WELWYN HATFIELD COUNCIL – DEVELOPMENT CONTROL
DELEGATED REPORT

APPLICATION No:	S6/2007/1139/FP
------------------------	------------------------

The application seeks full planning permission for demolition of the existing garage and erection of a two storey side extension with dormer windows.

Project: 93 The Ridgeway Cuffley
 Drawing: Proposed Scheme Plans and Elevations
 Date: July 2007
 Scale: 1:100
 Drawn: mRn 8504/P/003 b

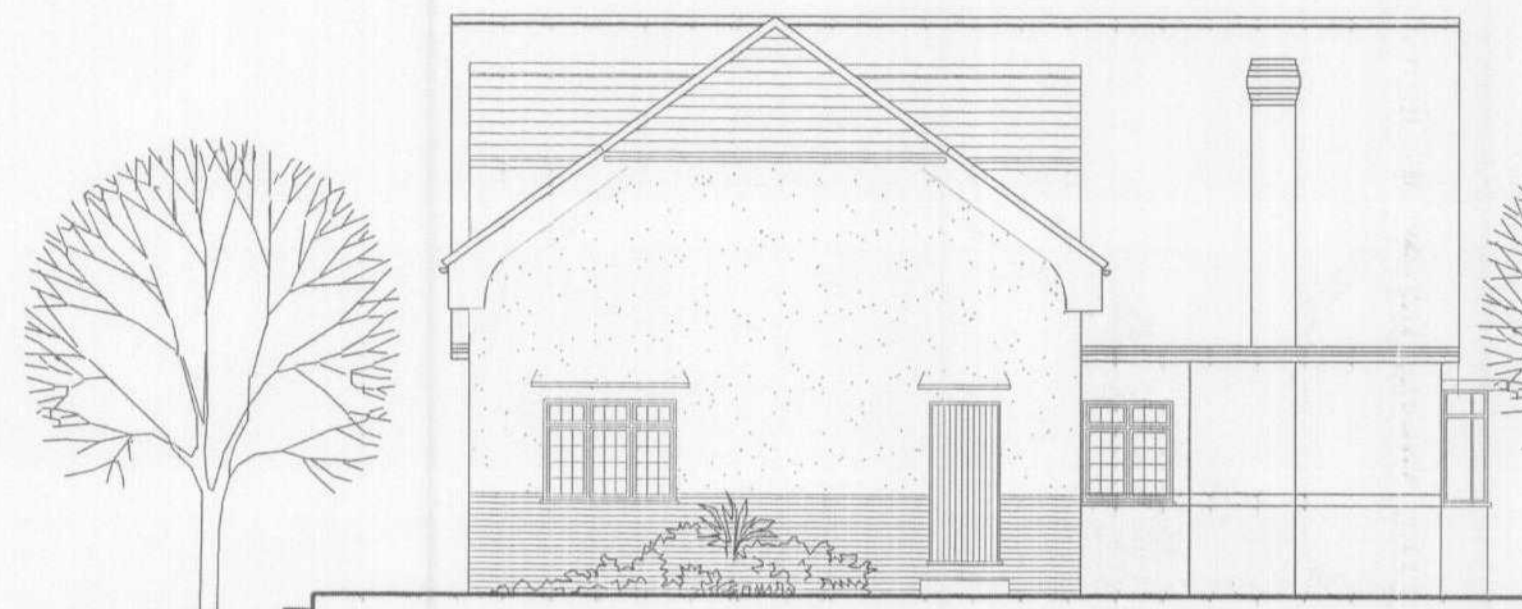
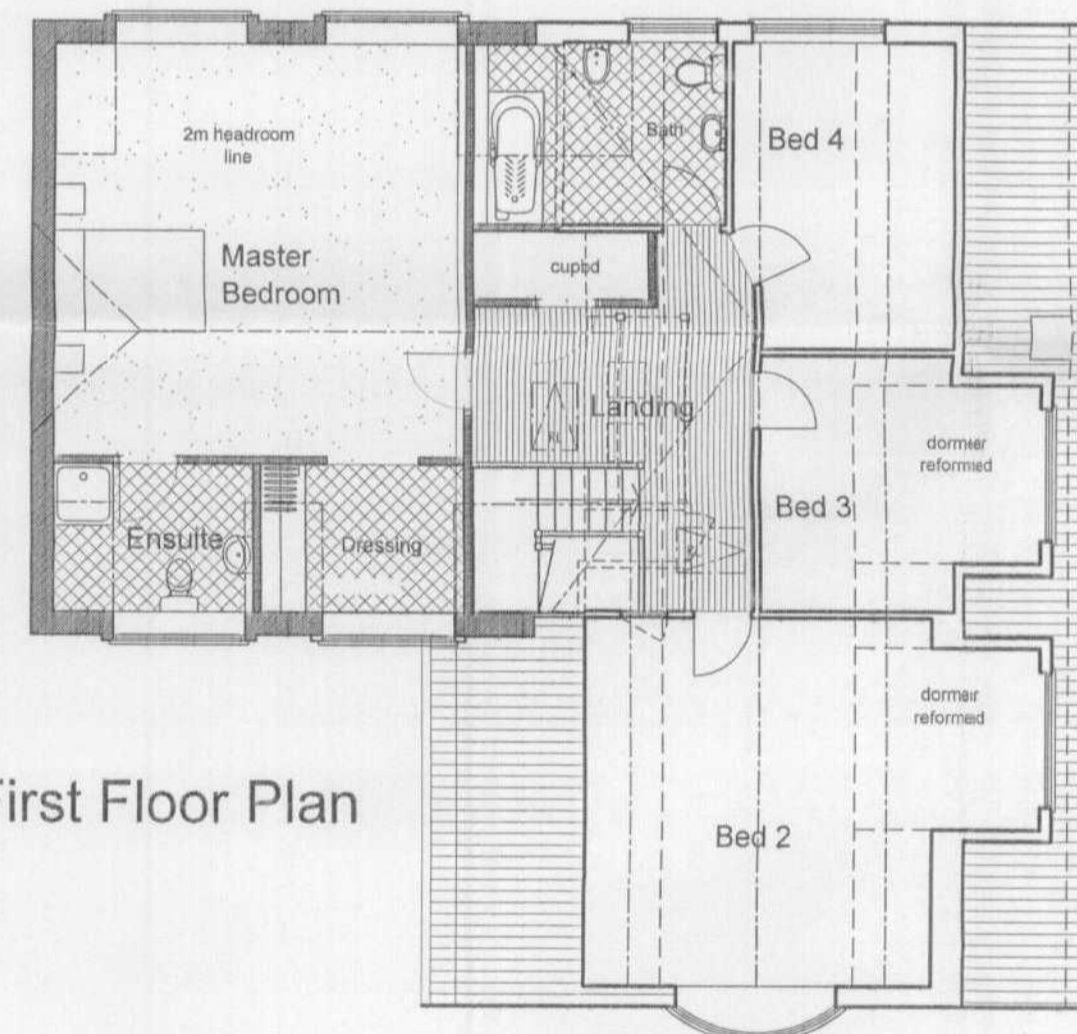
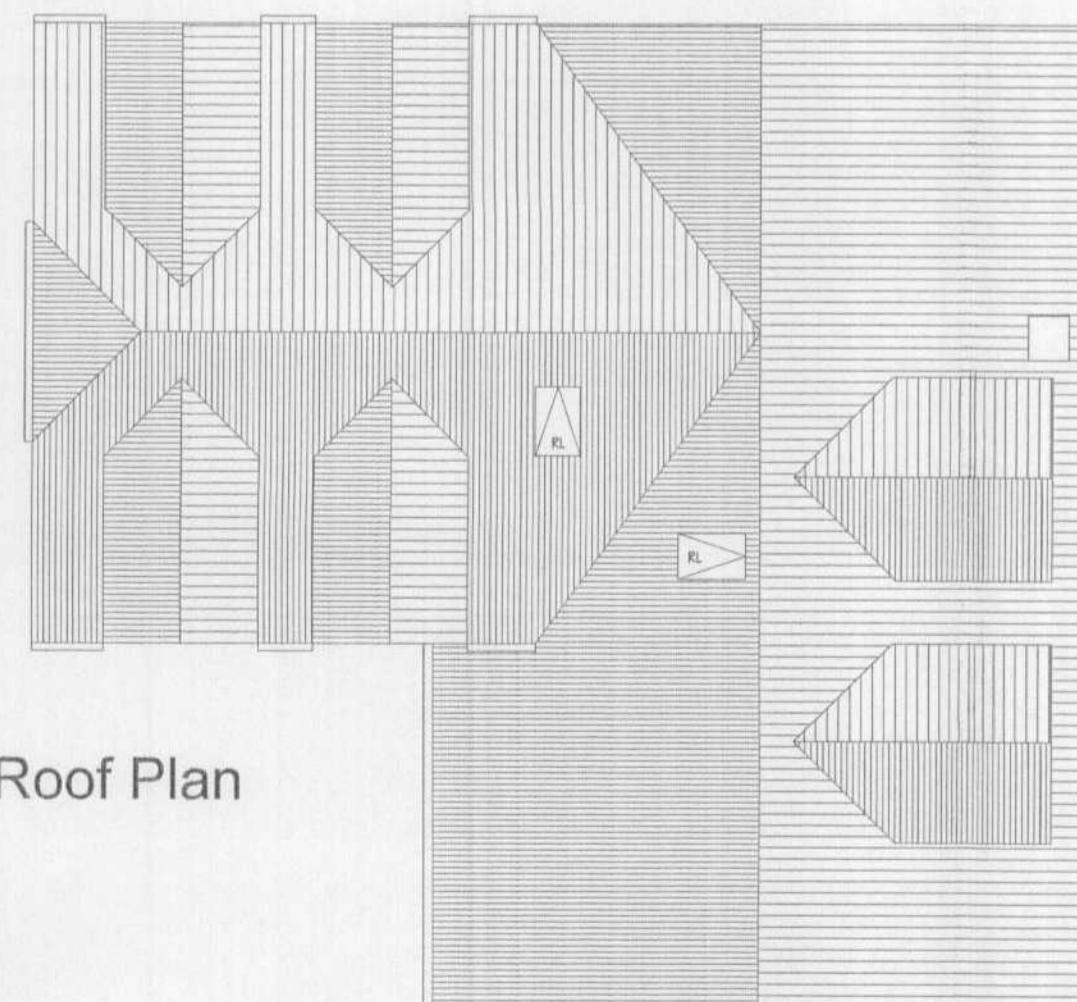
From looking at the figures it is considered that an increase in floorspace of 130.5 sq.m (78%) and footprint of 69.5 (66%) are considered to be disproportionate to the original dwelling and therefore fail to comply with section (i) of Policy RA3 (Extension to Dwellings in the Green Belt).

However, it is also important to consider the overall visual impact of the extension in relation to its prominence, size, bulk and design on the openness of the Green Belt. The erection of a first floor side extension would have a significant visual impact on the openness of the Green Belt and would close up an existing visual gap above the existing garage. The extension would be prominent due to its size, bulk and design of the two storey extension and the insertion of further dormer windows would add additional bulk to the roof slope. This complies with section (ii) of Policy RA3 (Extensions to Dwellings in the Green Belt).

The proposed extension would maintain the pitch of the existing roofline with a continuation to the east elevation. This would be finished with a gabled end with a hipped top section. This is considered to be appropriately designed and would respect and relate to the original dwelling and character of the street scene, particularly given that the low eaves height and dormer windows would be maintained. The immediate street scene contains a number of chalet style dwellings and it is considered that the proposed dwelling would reflect the existing architectural pattern within the street scene. This complies with Policies D1 and D2 of the Welwyn Hatfield District Plan 2005 and material contained within the Supplementary Design Guidance 2005.

The proposed dormer windows comply with Section 5.1 vi of the Supplementary Design Guidance as they are located below the ridge height, in proportion to the existing fenestration and 1m from the adjoining party walls. They have also been designed to emulate the existing design of the side dormer windows with a gabled roof and therefore would not detract from the character of the house. This complies with Policy D1 of the Welwyn Hatfield District Plan 2005.

It is considered that the double storey extensions would not have a detrimental impact on residential amenity in terms of dominance, overbearing or loss of sunlight/daylight to the occupiers of 91 The Ridgeway. The ground floor windows along this elevation consist of secondary windows to the rear living room and at first floor level there is one small window to serve a bathroom. The extension would not protrude further to the rear than the existing rear most point of the existing dwelling. This complies with Policy D1 of the Welwyn Hatfield District Plan 2005 and the material contained within the Supplementary Design Guidance 2005.

The dormer windows would not create unacceptable loss of privacy to either adjoining sites as they would be placed within the front and rear elevations and therefore predominantly have views towards the street scene and rear garden. This complies with Policy D1 and the material contained within the Supplementary Design Guidance 2005.

The proposed two storey side extension including dormer windows would result in a disproportionate increase in the size of the dwelling and have an adverse visual impact (in terms of its prominence, size, bulk and design) on the character and openness of the Green Belt. Consequently, this fails to comply with Policies RA1 and RA3 of the Welwyn Hatfield District Plan 2005.

1) The proposal by virtue of the size, bulk, scale and design would result in a disproportionate addition over and above the size of the original dwelling and therefore represent inappropriate development within the Green Belt. The applicant has failed to demonstrate to the satisfaction of the Local Planning Authority any very special circumstances exist to outweigh the harm caused by reason of its inappropriateness. In addition, the proposal by virtue of its siting, design and bulk would have a detrimental impact on the character and openness of this part of the Green Belt and the visual interest of its surroundings. The proposal is therefore

contrary to the advice contained within PPG2 and Policies RA3, D1 and D2 of the Welwyn Hatfield District Plan 2005.
